25 January 2019

Director - Infrastructure Projects
Department of Planning and Environment
Application number SSI_8931
GPO Box 39
SYDNEY NSW 2001

Georges River Council Submission
F6 Extension Stage 1 – New M5 Arncliffe to President Avenue, Kogarah

Figure 8-37 President Avenue / Princes Highway intersection indicative layout

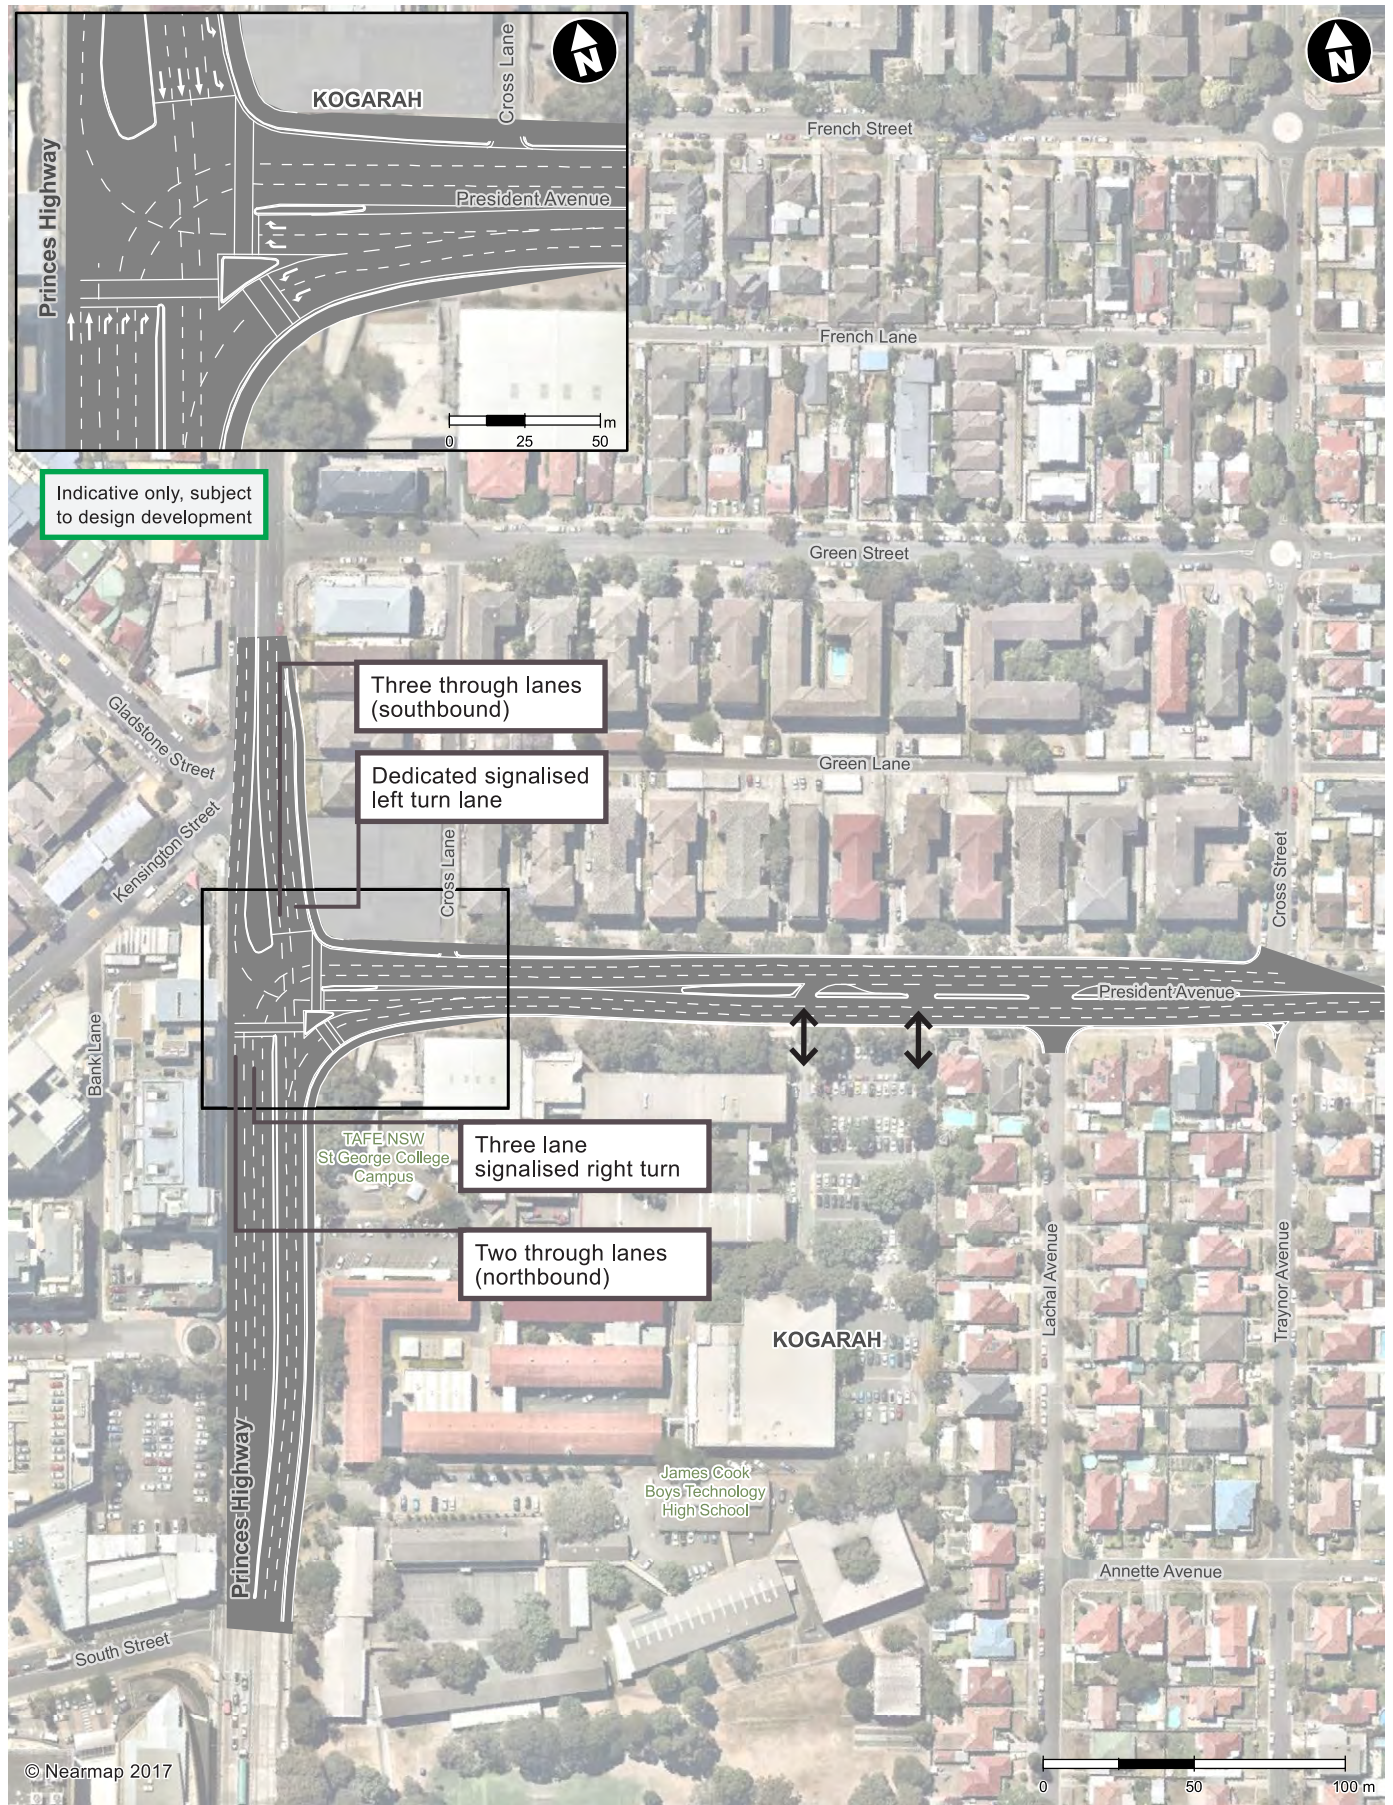
The proposal to increase the capacity at the President Avenue and Princes Highway intersection has the potential to increase network pressure, increase delay times at the intersection during peak hours, and increase travel time for buses.

The EIS acknowledges that delay time at the intersection will increase during AM and PM peak hours.
